May 25, 2021

Subject: BCH 93rd Lot 1 Building Permit Intake

In response to the intake comments received, April 22, 2021, I have completed revisions to the BCH 93rd Lot 1 Building Permit Plans. For your use and review the revised plans are included in the resubmittal package. The following is a description of the revisions.

T.E.S.C. PLAN
LOT 1 - SFR (93RD AVE SE)
PREMIUM HOMES OF MERCER ISLAND LLC
PO BOX 1639 98040
MERCE (206) 724-1072

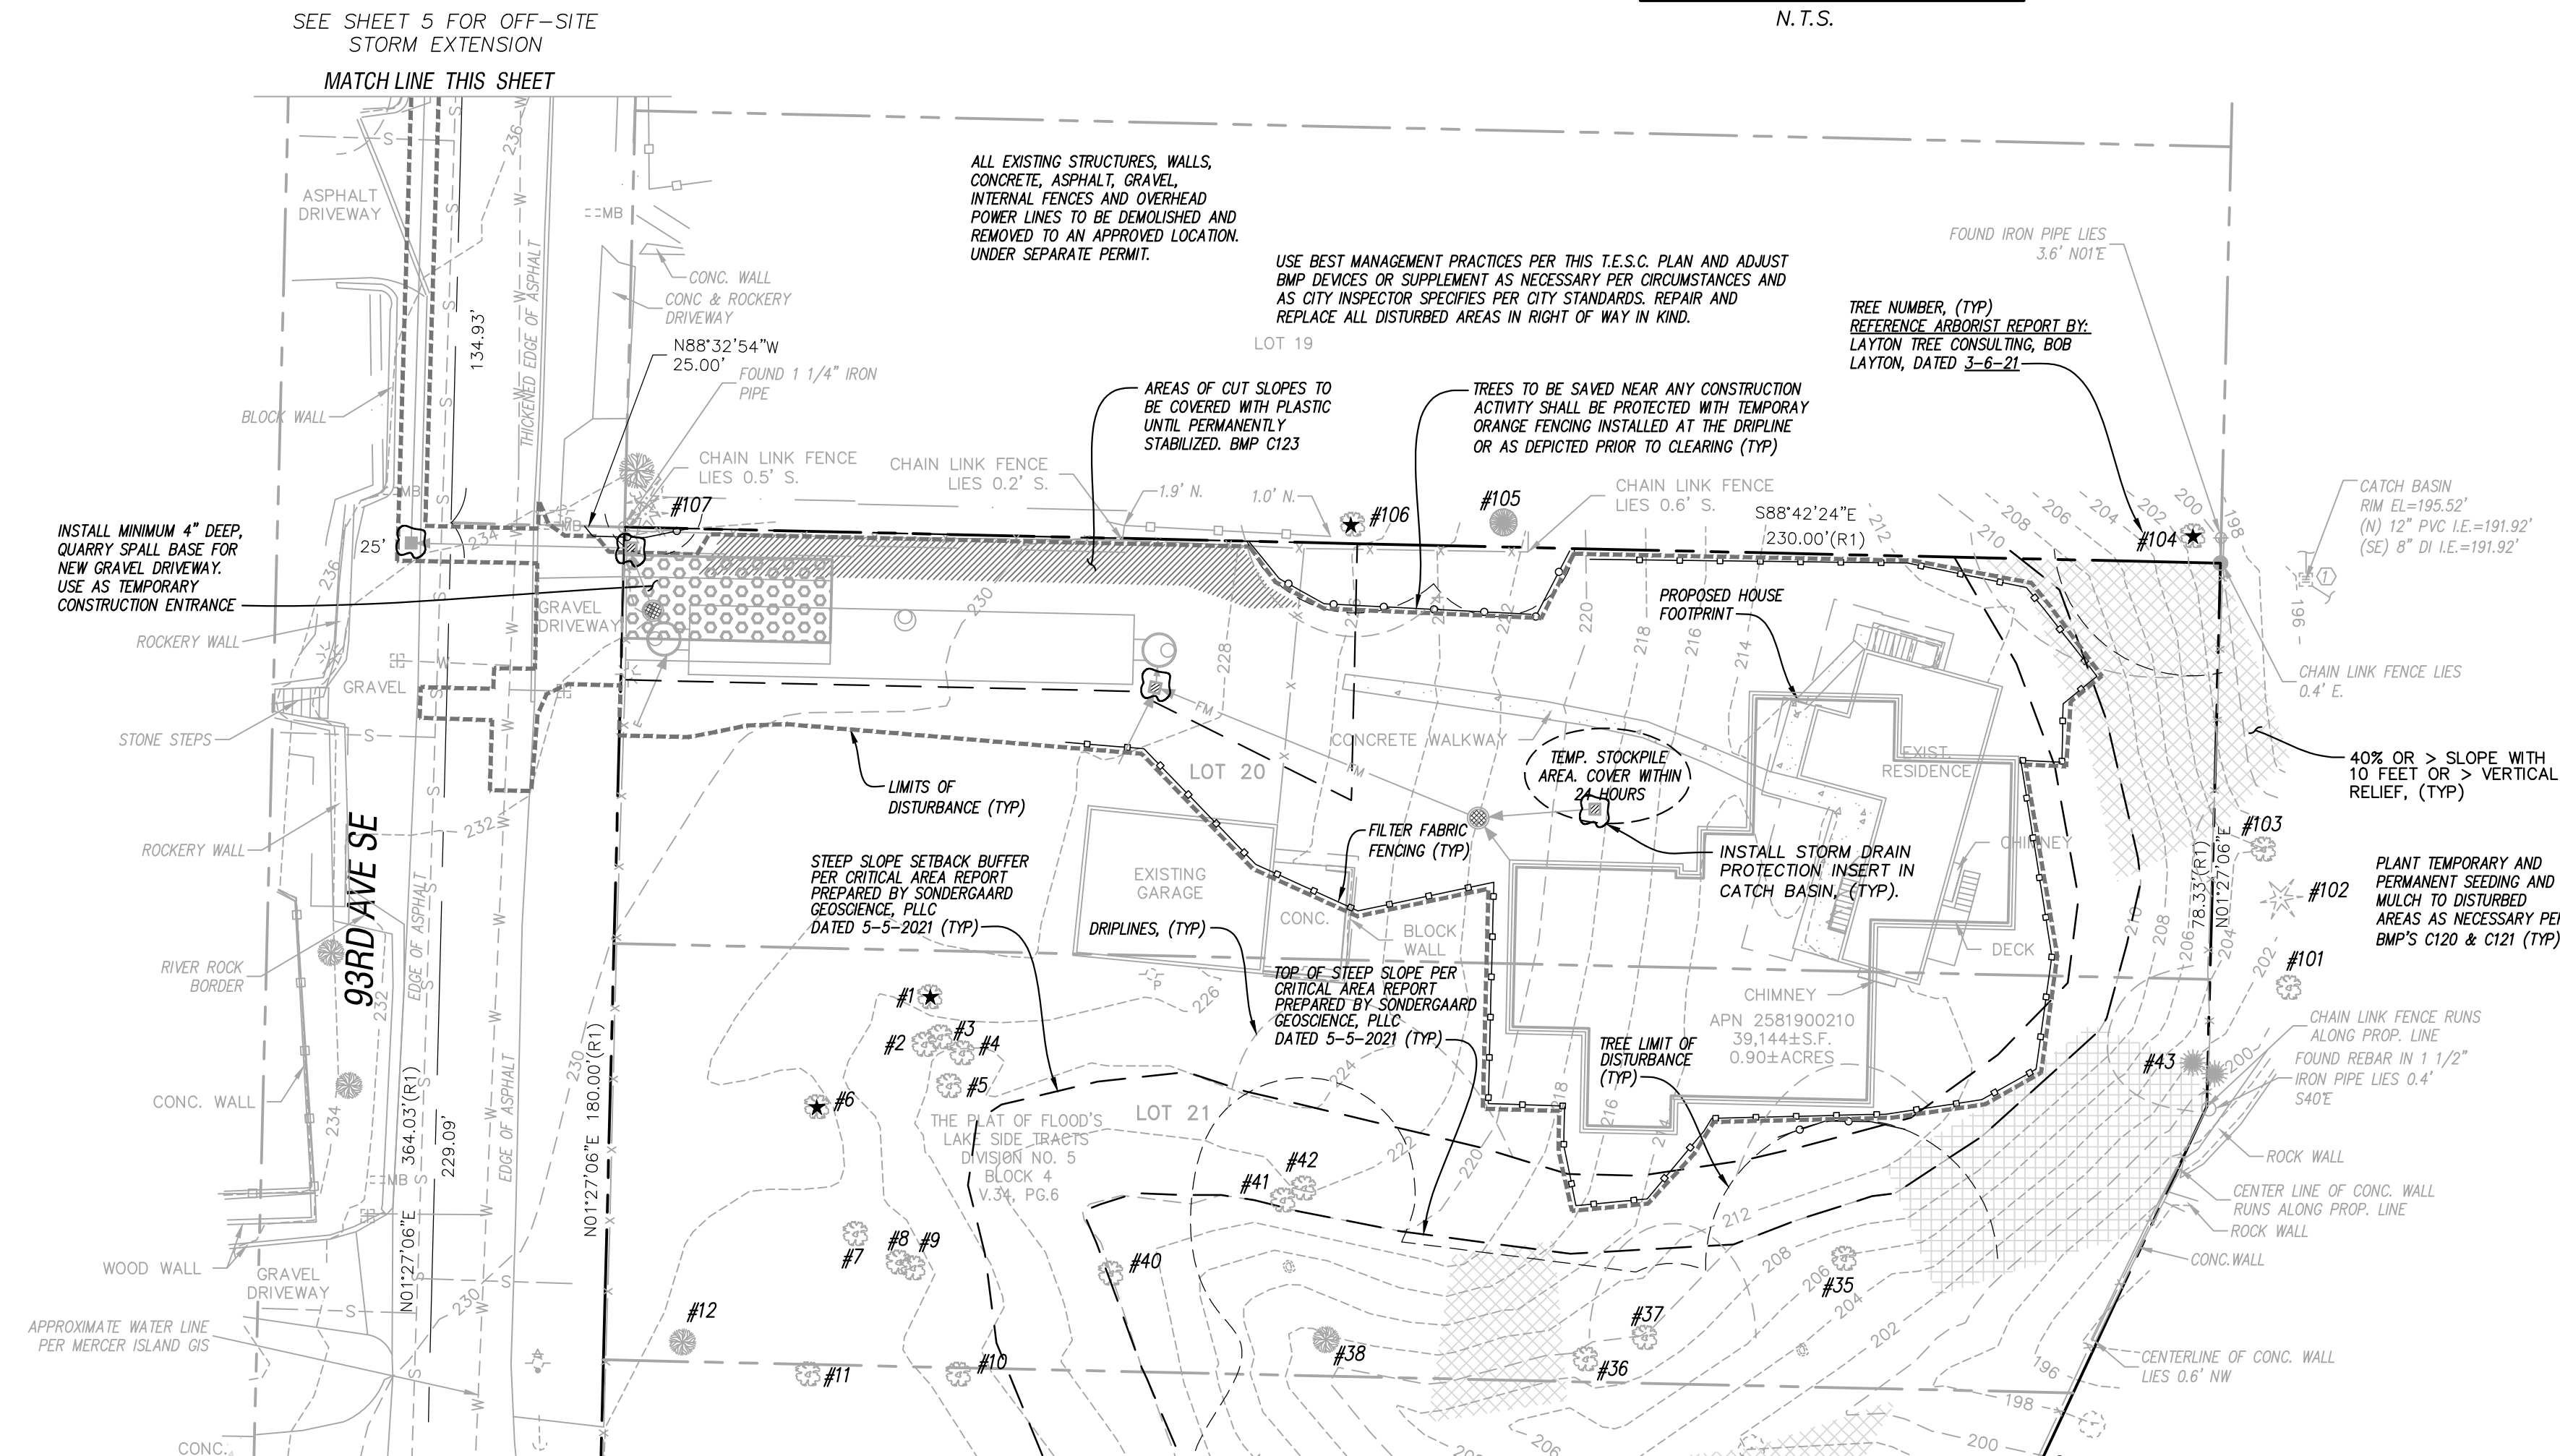
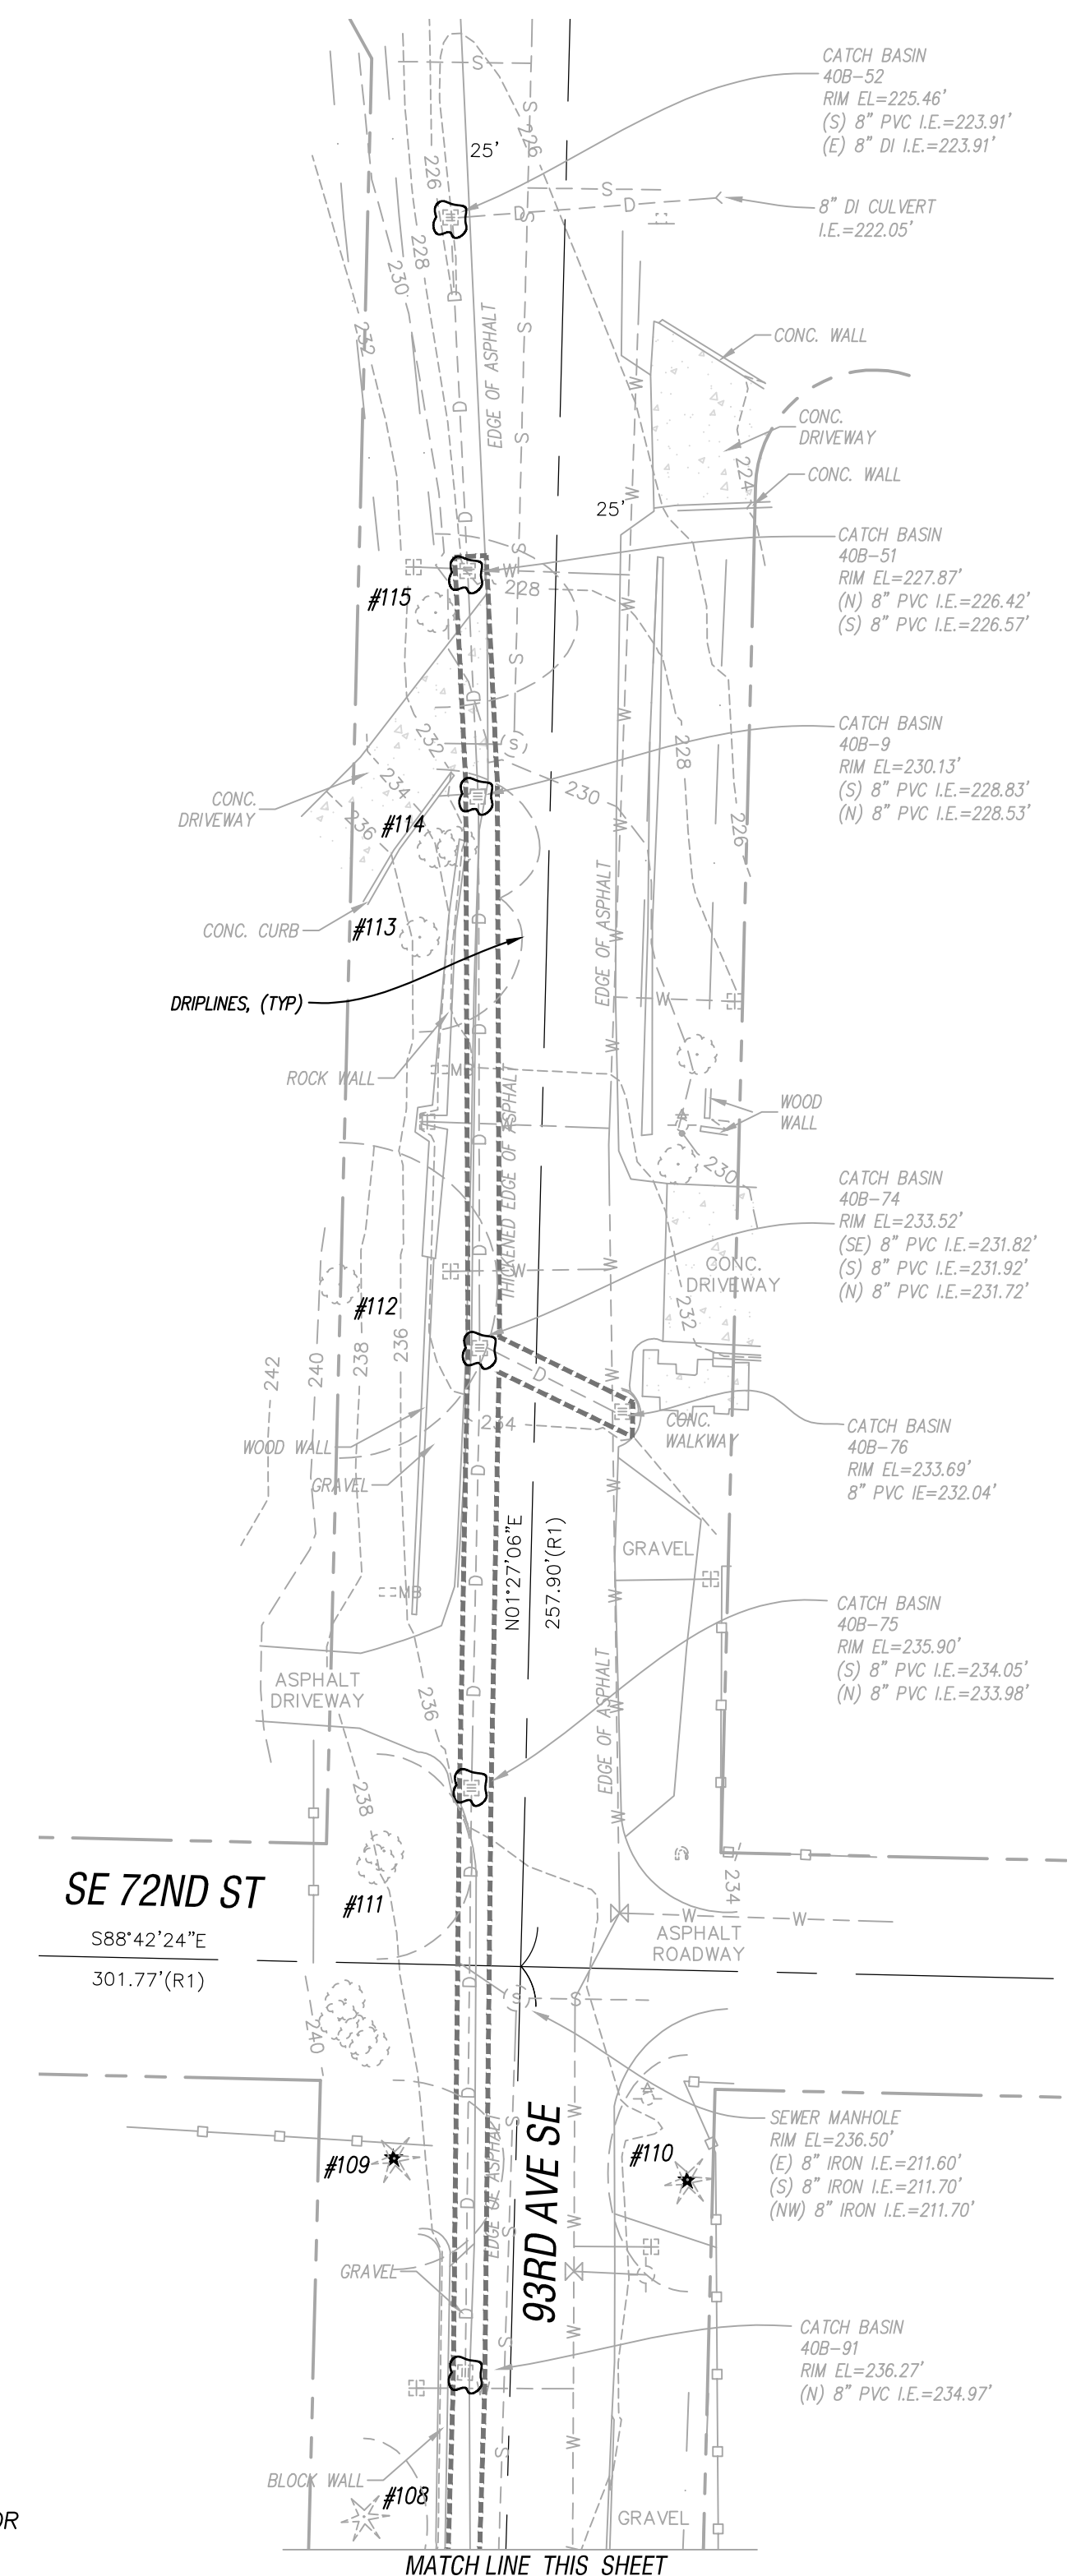
1. *TESC plan sheet 2 shows multiples trees to be removed away from proposed development. This plan may be for future plans. Update this plan to reflect other sheets and tree inventory worksheet stating no removals.*
The TESC plan has been revised to reflect the work associate with Lot 1's building permit.
2. *Provide a plan sheet called tree retention plan that includes all of the check boxes on this list including all utility information.*
A Tree Retention Plan has been added to the plan set.
